# CITY OF PORTLAND, MAINE

July 29, 2016

Project Name: "Station 415" Subdivision and Change of Use: Co-Working Office Unit  
and three (3) Apartments

Project ID: #2016-152  
Address: 415 Cumberland Avenue CBL: 036 G033001  
Applicant: Andrew Kraus, M & A Lowcountry Investments, LLC  
Planner: Jean Fraser

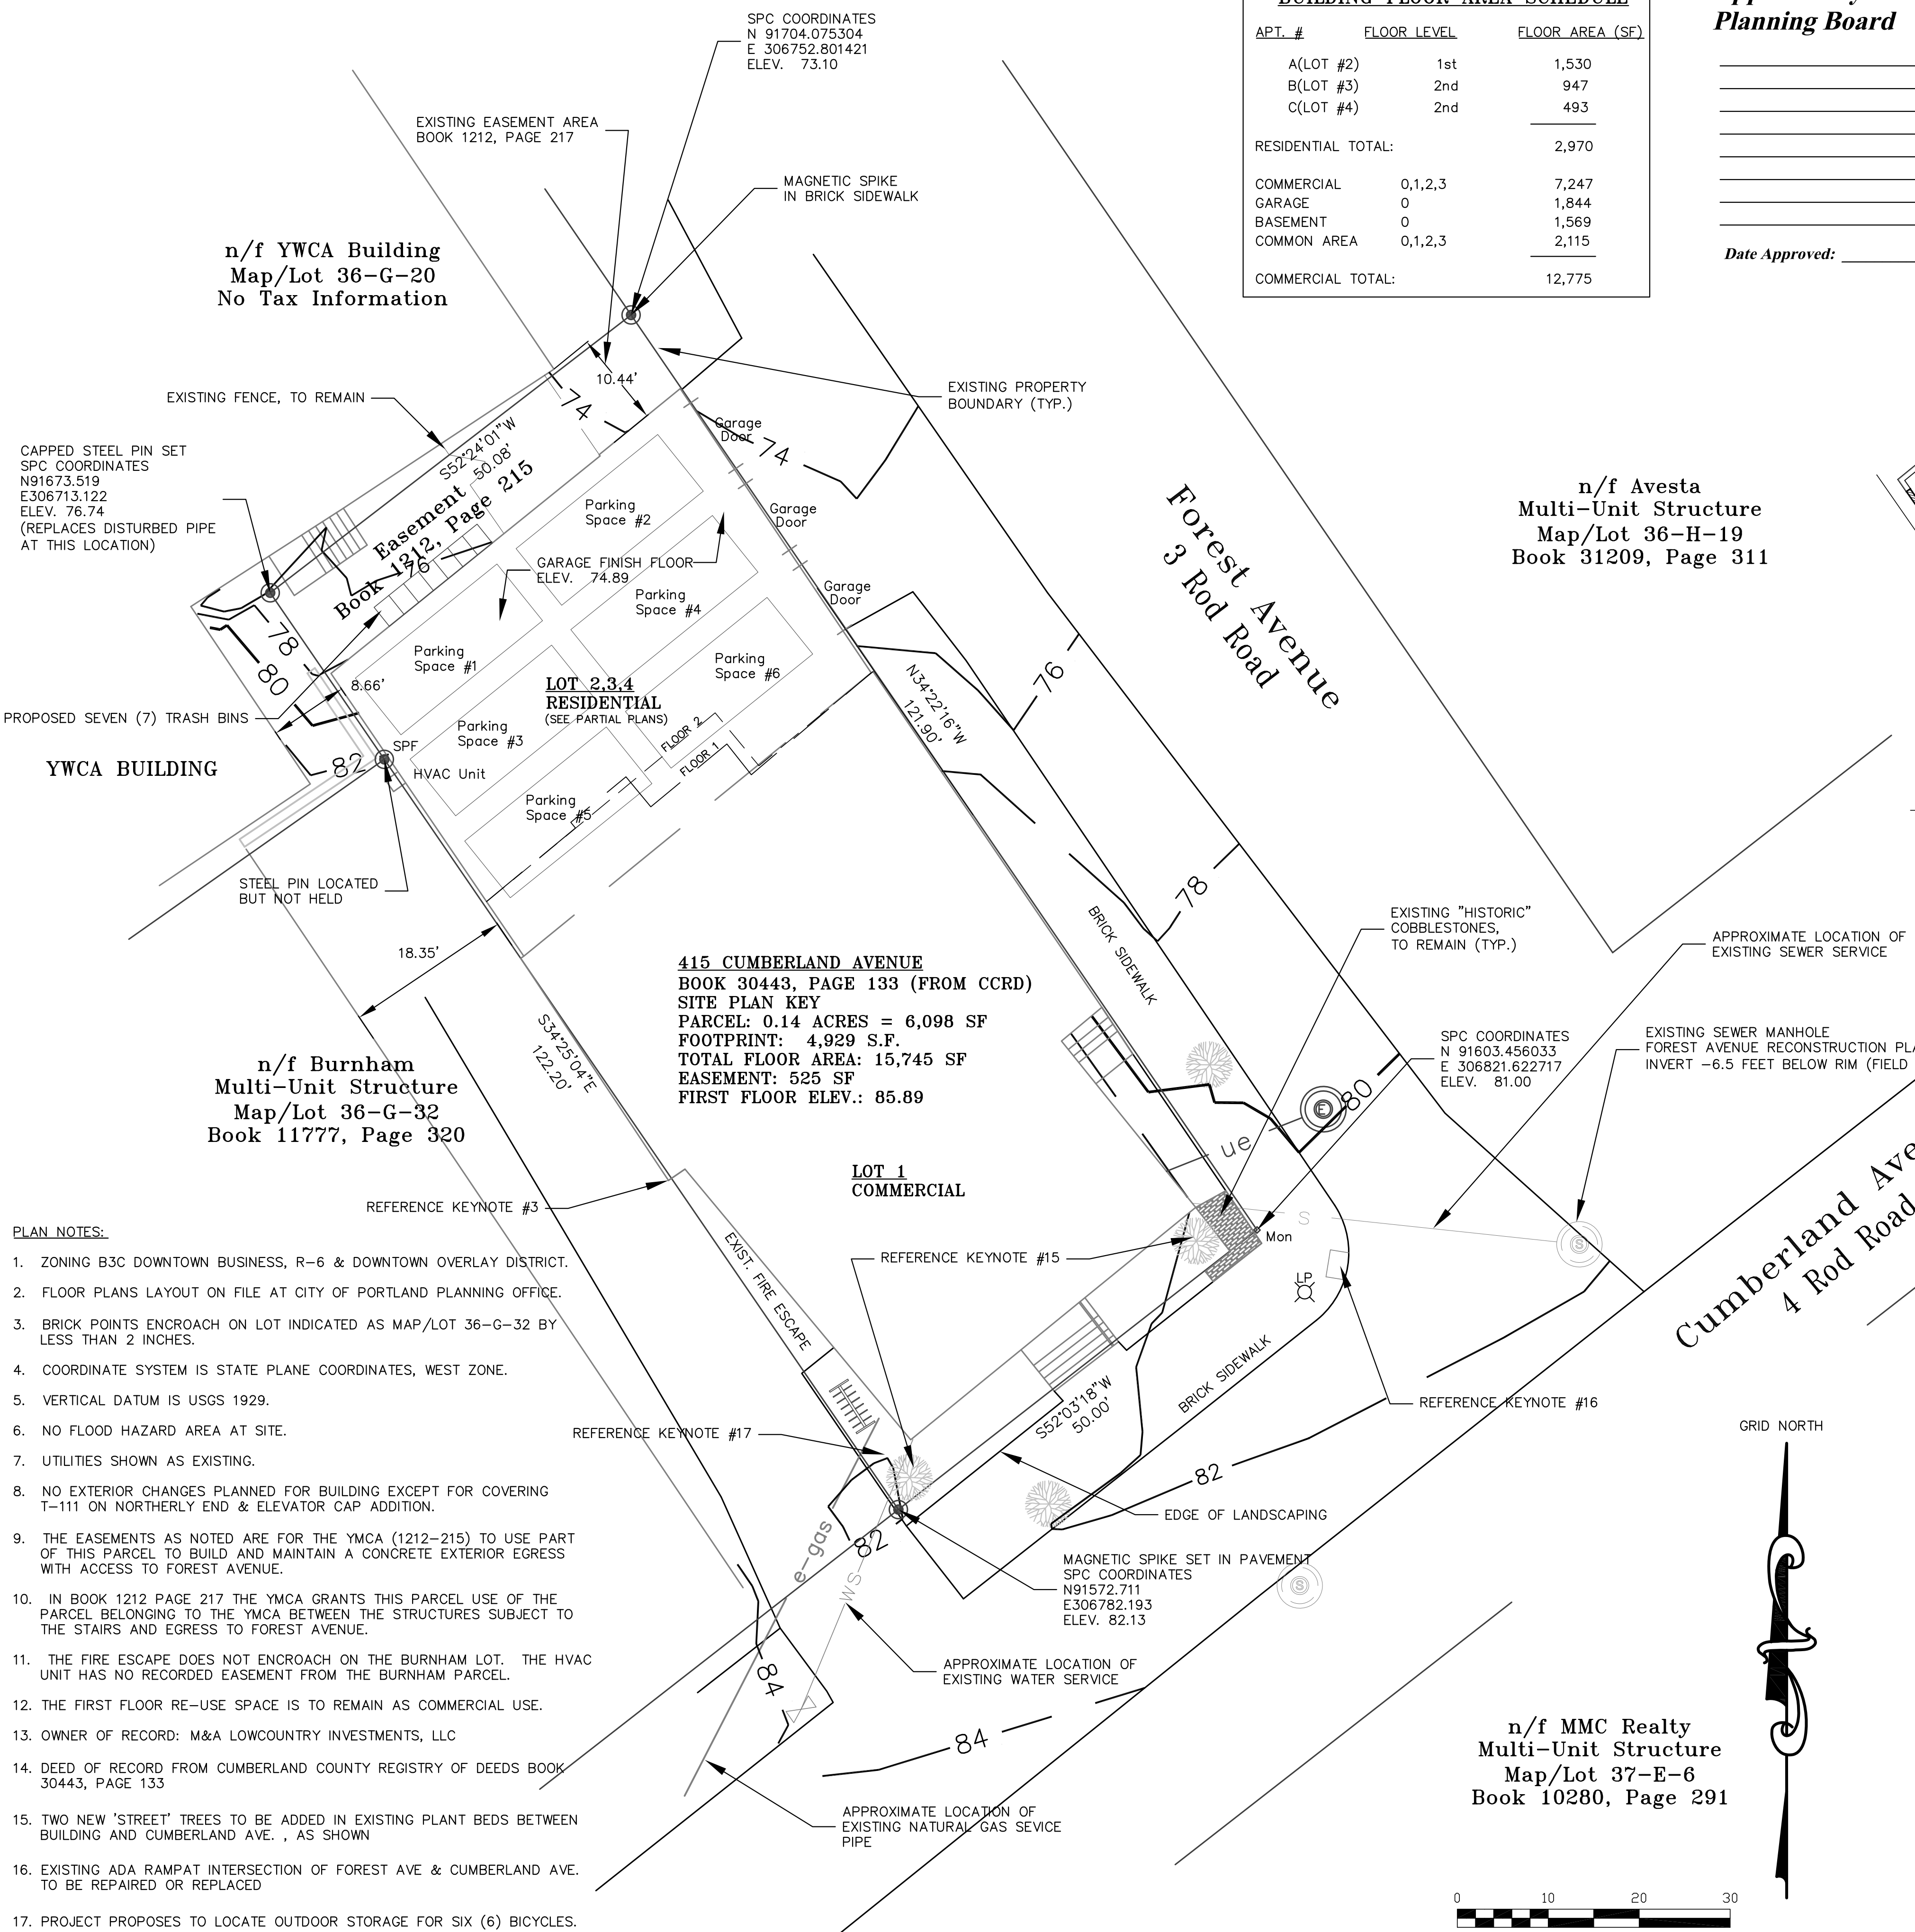
- i.* That the Subdivision Plat shall be finalized to the satisfaction of the Planning Authority, Corporation Counsel, and Department of Public Works, and include clarification of easement and other information along with relevant notes and conditions prior to submission for Planning Board signature; and
- ii.* That in the event the property is converted to a condominium, that the recorded condominium documents shall be copied to the Planning Authority.

FOREST AVENUE ELEVATION  
 SCALE: 1/8" = 1'-0"

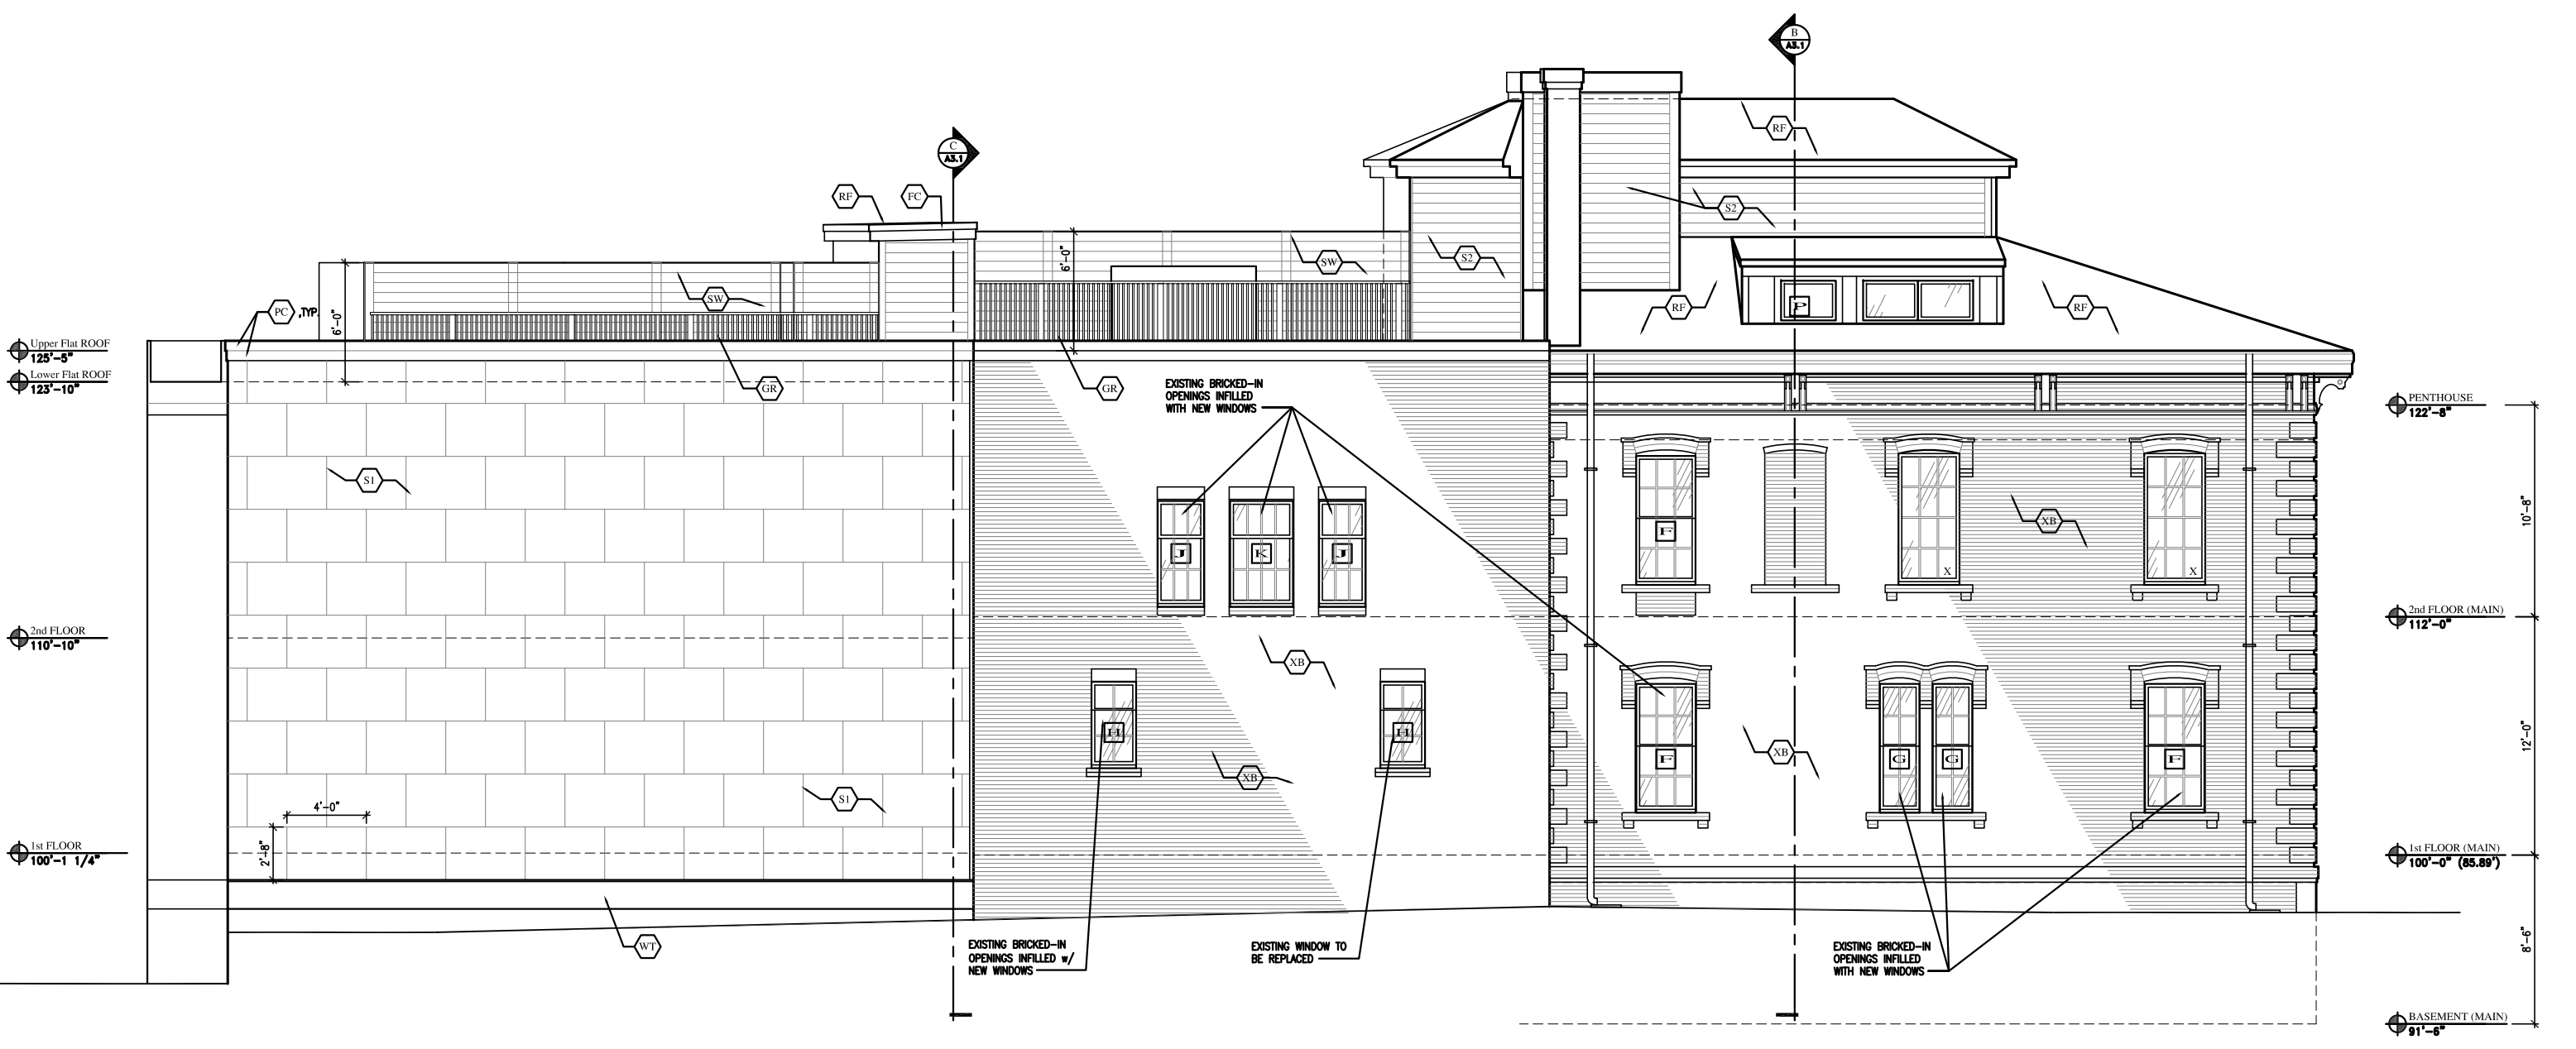
- D) The route to the outside bike racks located within the applicant's property; and
  - E) Improved screening of the trash storage area.
- ii. That the applicant address the comments of the Historic Preservation Manager dated 7.21.2016 in respect of the tone of proposed new cladding on the Forest Avenue elevation, prior to the issuance of a building permit; and

The 7/20 design appears to be responsive to most of the previous review comments provided by this office, as well as comments of the Planning Board and staff. The one outstanding issue that might warrant further consideration is the replacement exterior cladding proposed for the rear addition facing Forest Avenue. Although the material itself is acceptable and its running bond pattern relates to the running bond brick of the abutting historic structure, staff suggests that the scale of the individual cement panels be reduced somewhat. A reduction in scale of individual modules would likely result in a more subtle and intentional relationship between the finer grain brick of the historic structure and the contemporary exterior of the addition. Also, staff suggests that the tone of the addition be darker than what is presented to provide a more recessive appearance.

ARCHITECTURAL  
 SITE  
 PLAN

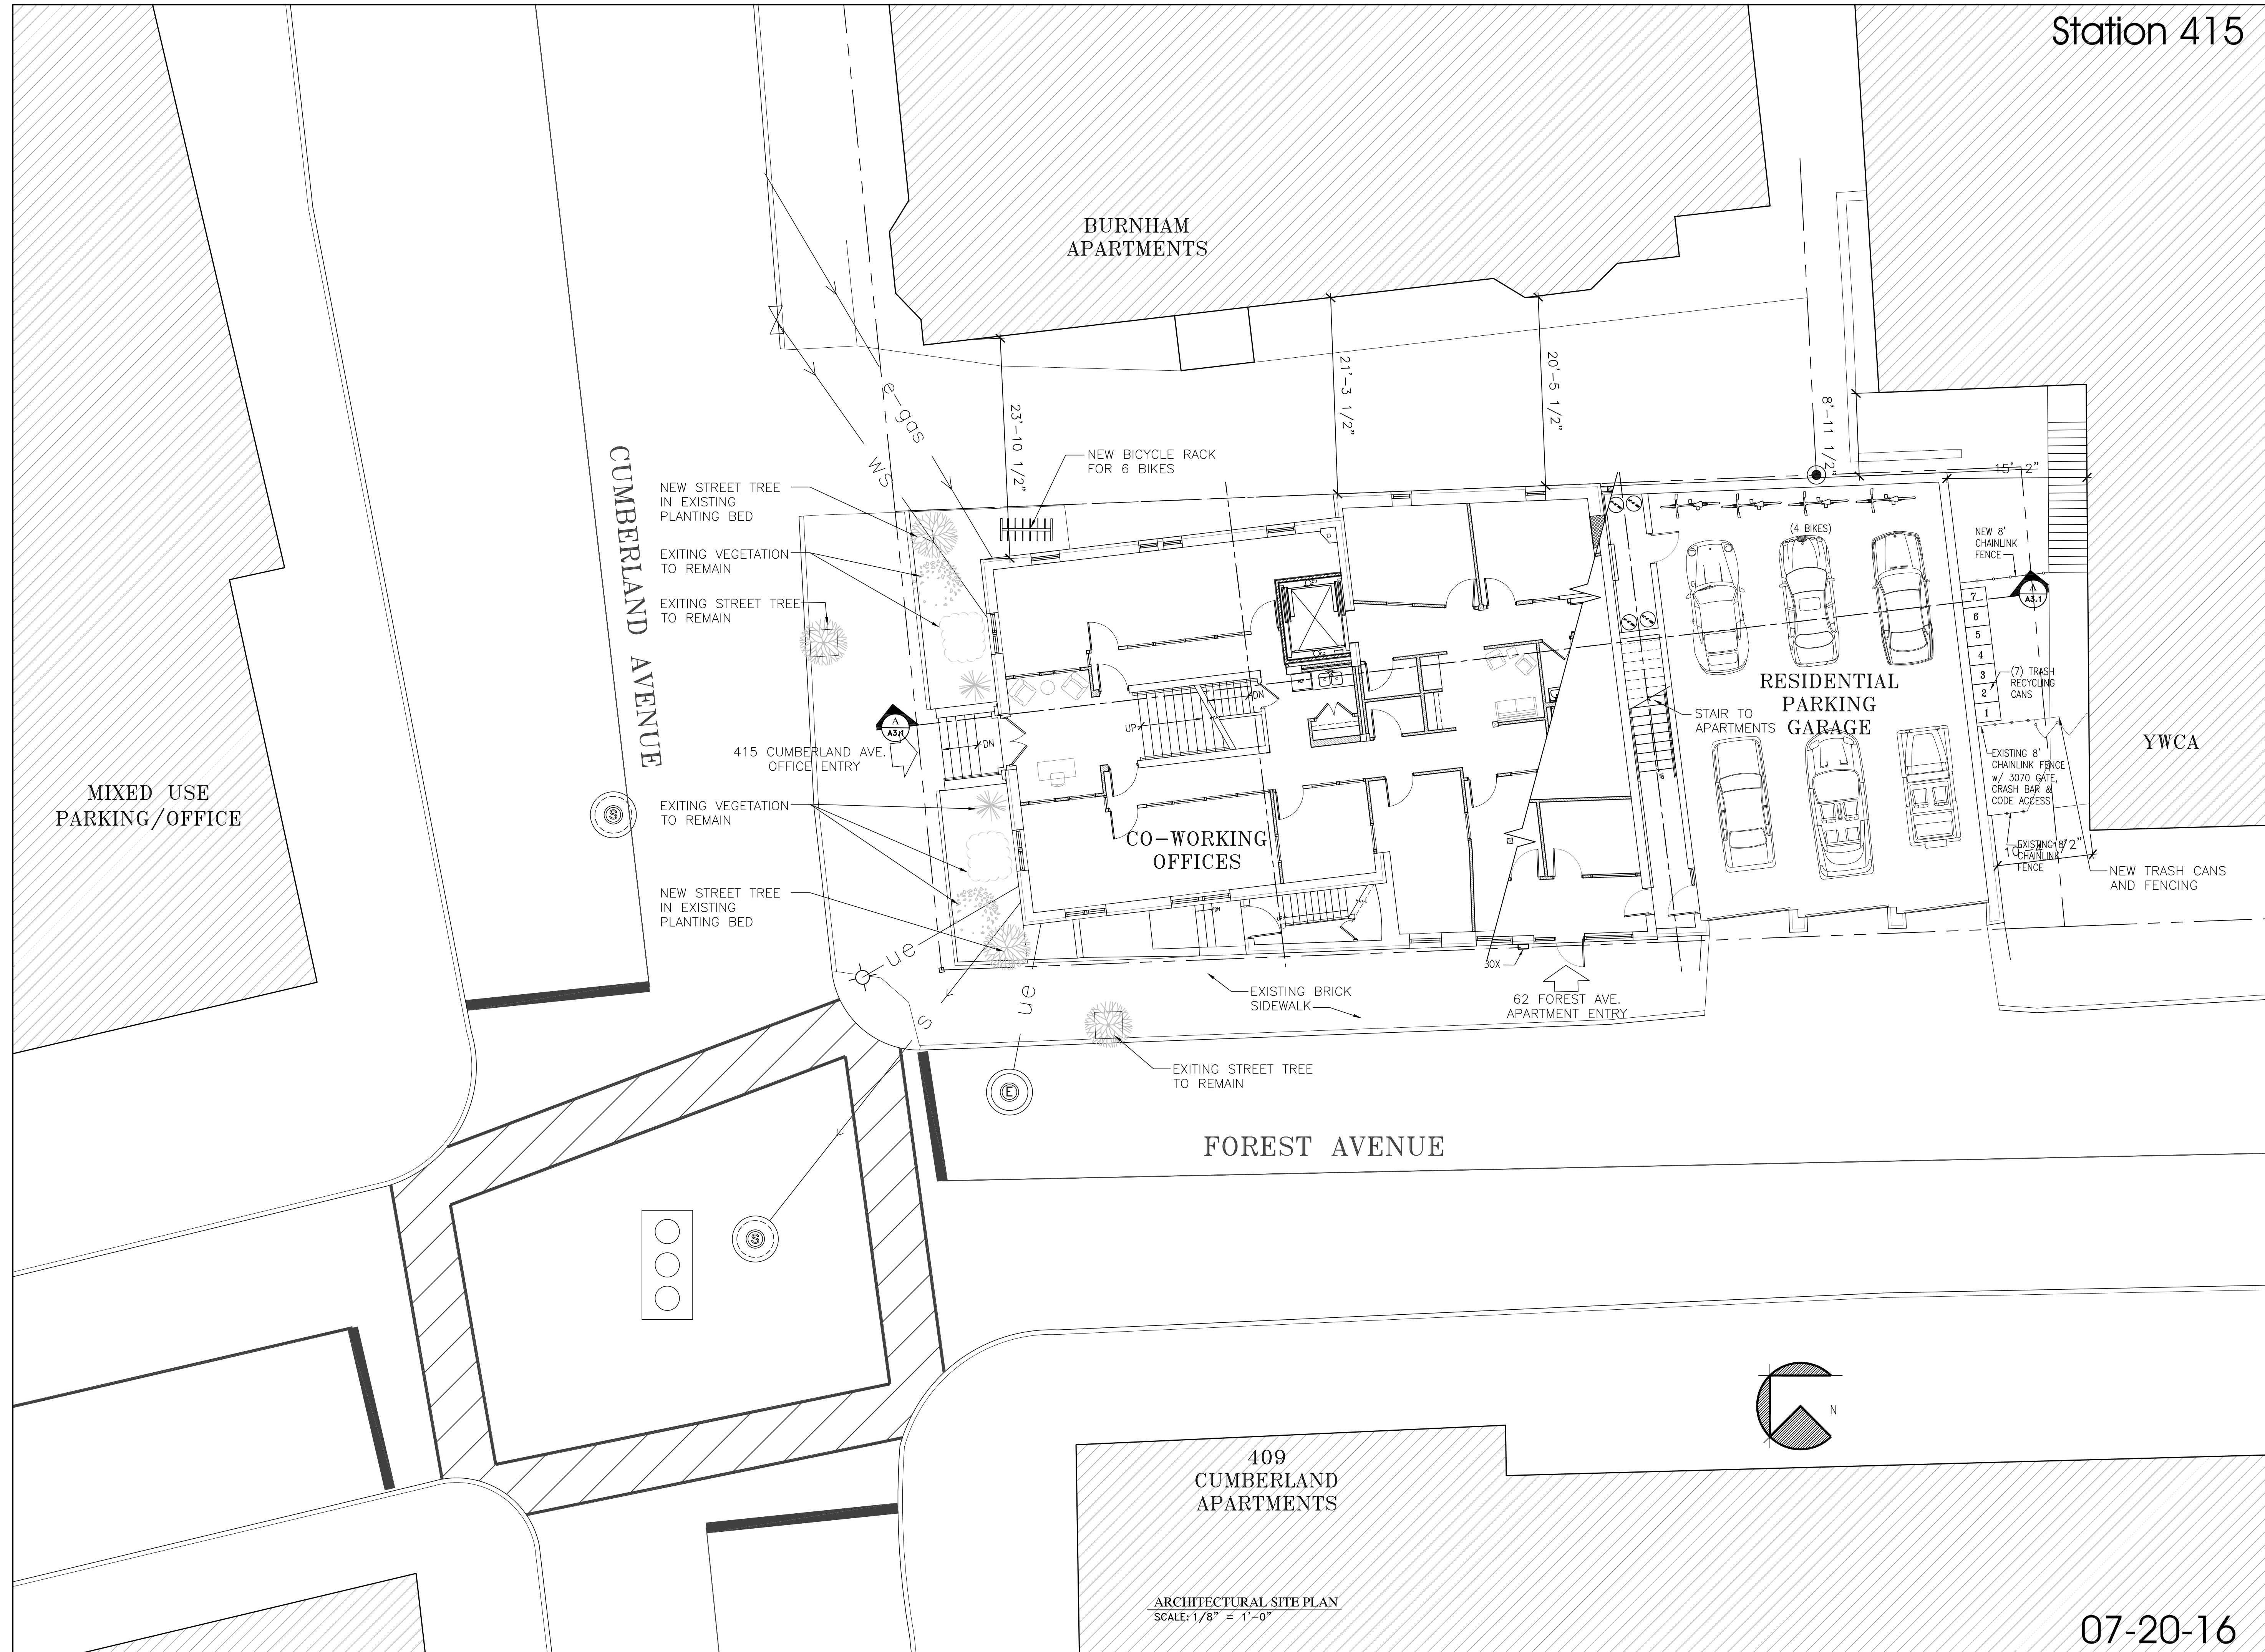
- A) The locations of roof drains and their discharge locations, with surface erosion protection noted as necessary (roof drains shall not discharge into the sewer);

- C) The repair/replacement of the ADA ramp panel in the ROW at the corner of Forest Avenue and Cumberland Avenue (to meet the City's Technical Standards for any work in the ROW);
